Recommendation Report for Planning Permission for Works or Extension to a Dwelling

REF NO: R/206/21/HH

LOCATION: 1 Ingram Close
Rustington
BN16 3NZ

PROPOSAL: Erection of front porch extension following demolition of existing front porch

PROPOSED FLOOR PLAN

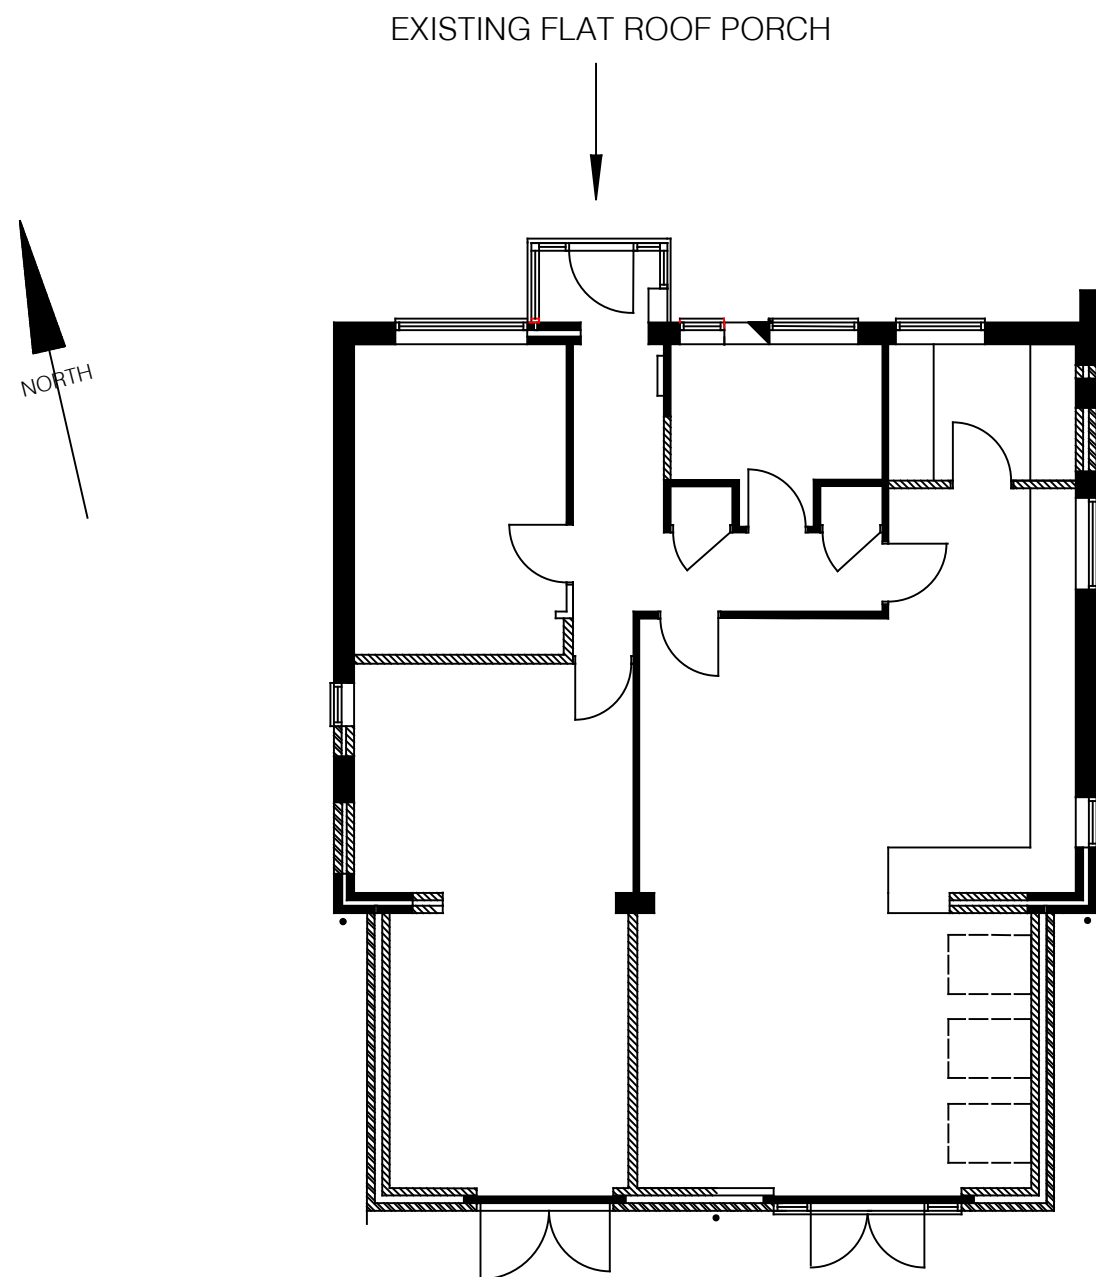
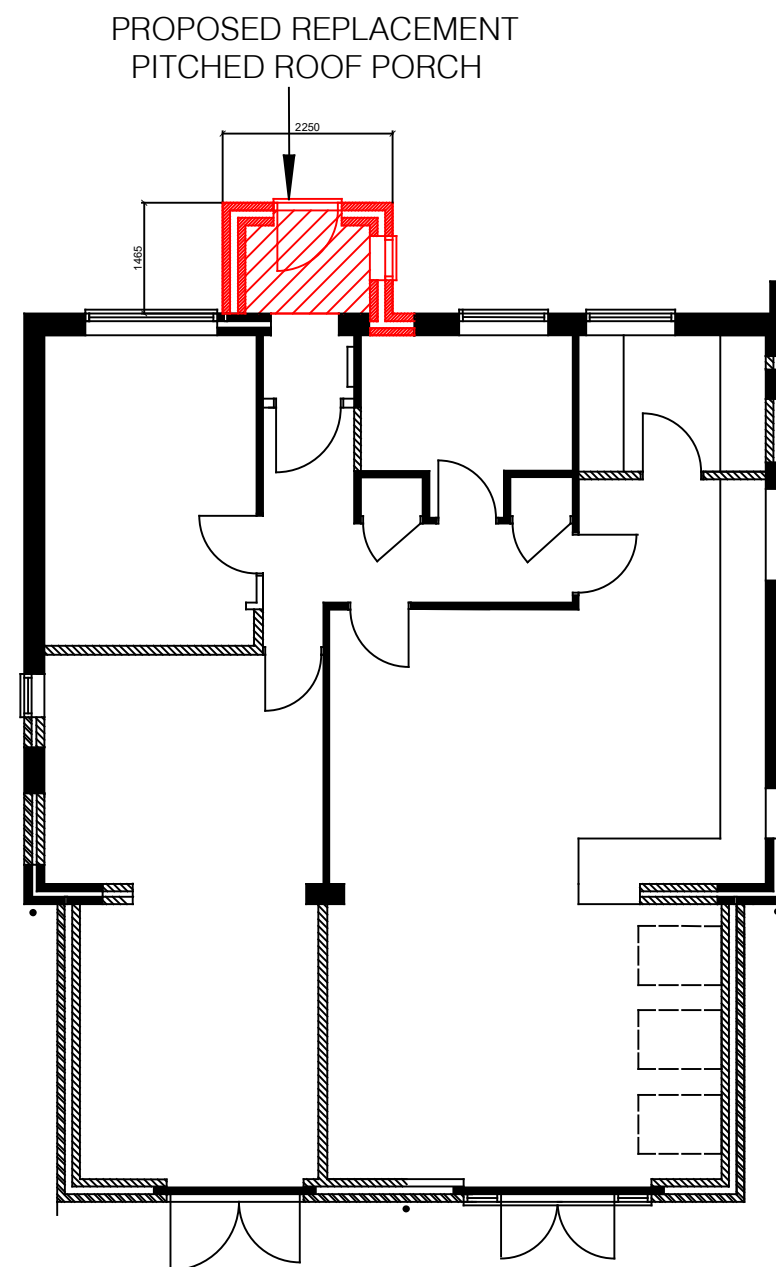
DESCRIPTION OF APPLICATION	This application seeks the demolition and replacement of a porch measuring 2.25m wide by 1.5m in depth.
----------------------------	---

The porch is to be located centrally to the front of the building. As it is significantly smaller in scale than the existing building, and as it does not reduce any minimum separation gaps between dwellings, it is considered not to be overbearing or overshadow neighbouring properties.

Drawing Title ; EXISTING AND PROPOSED ELEVATIONS ELEVATIONS

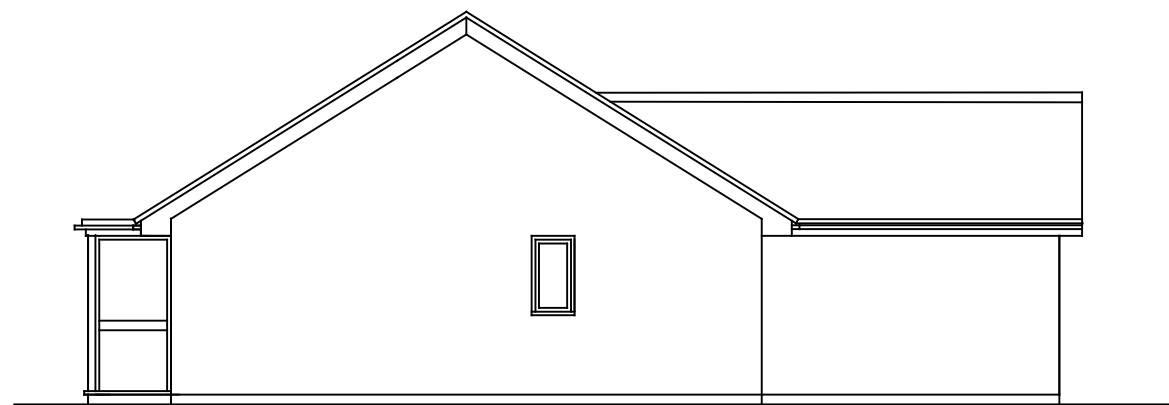
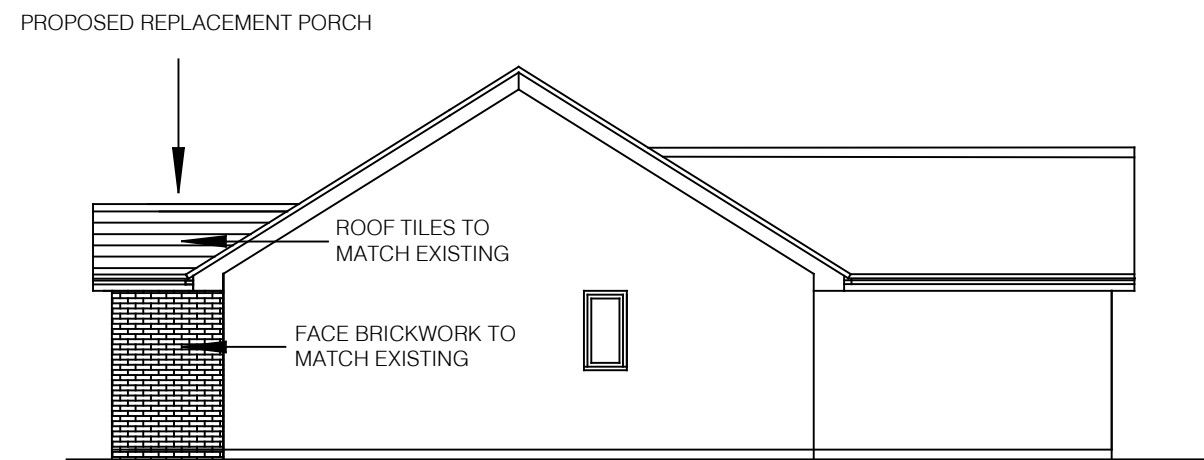
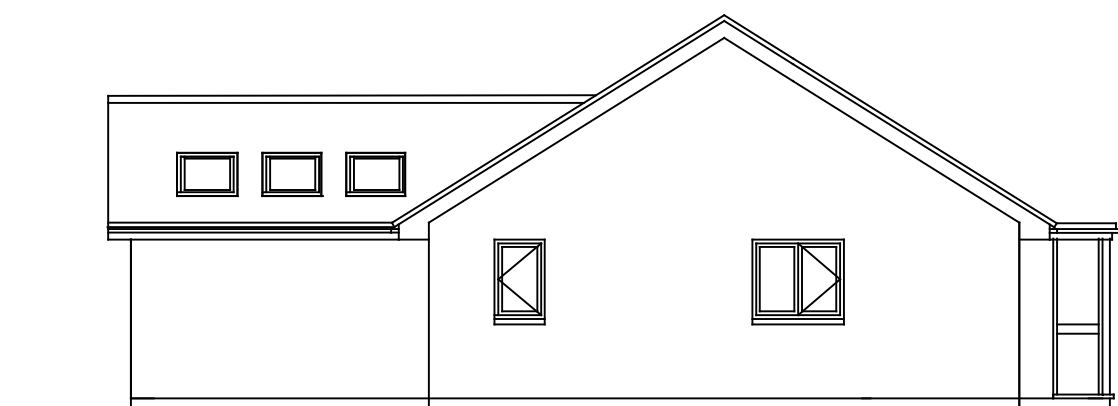
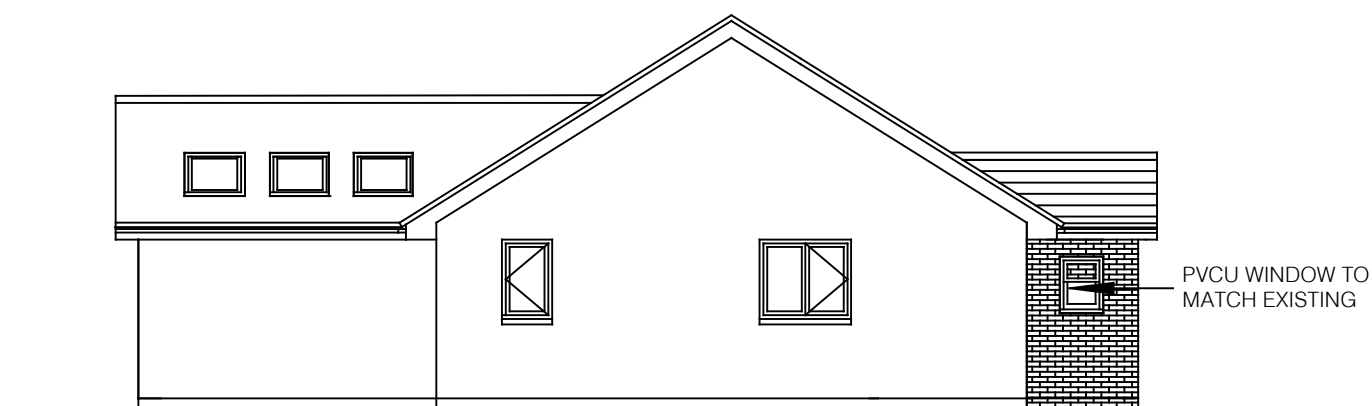
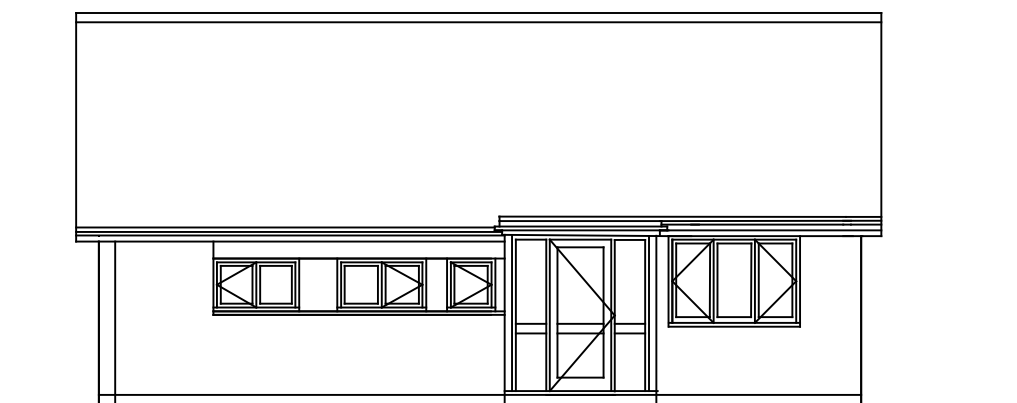
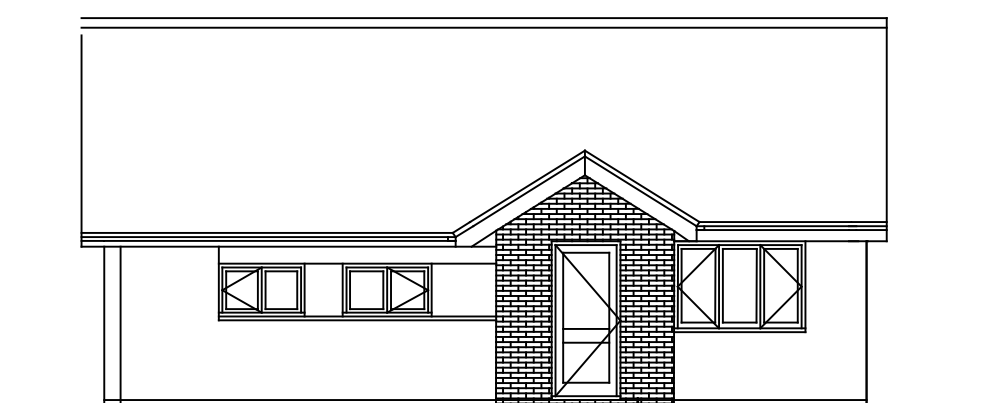
The proposed porch is to replace an existing porch which was of a similar size and scale albeit with a flat roof. The proposed porch includes a pitched roof with an eaves line to equal to the main roof and will be constructed with materials which match those currently found on site. The scale of the proposed porch is considered acceptable and in keeping with the host dwelling, given its lower ridge height it is considered subservient to the existing dwelling.

The porch is deemed an appropriate form of development when viewed in connection with the street scene. It is noted that similarly styled and scaled porches can be found on the street, including on the next door property. The porch will be subservient to the street scene and a more attractive form of development than the existing structure.

The porch contains one small ground floor window which will gain views across the frontages of the properties. Furthermore, the porch doesn't form new habitable space. It is considered that the views achievable are only those already available from the public realm and as such does not contribute to any negative overlooking from site.
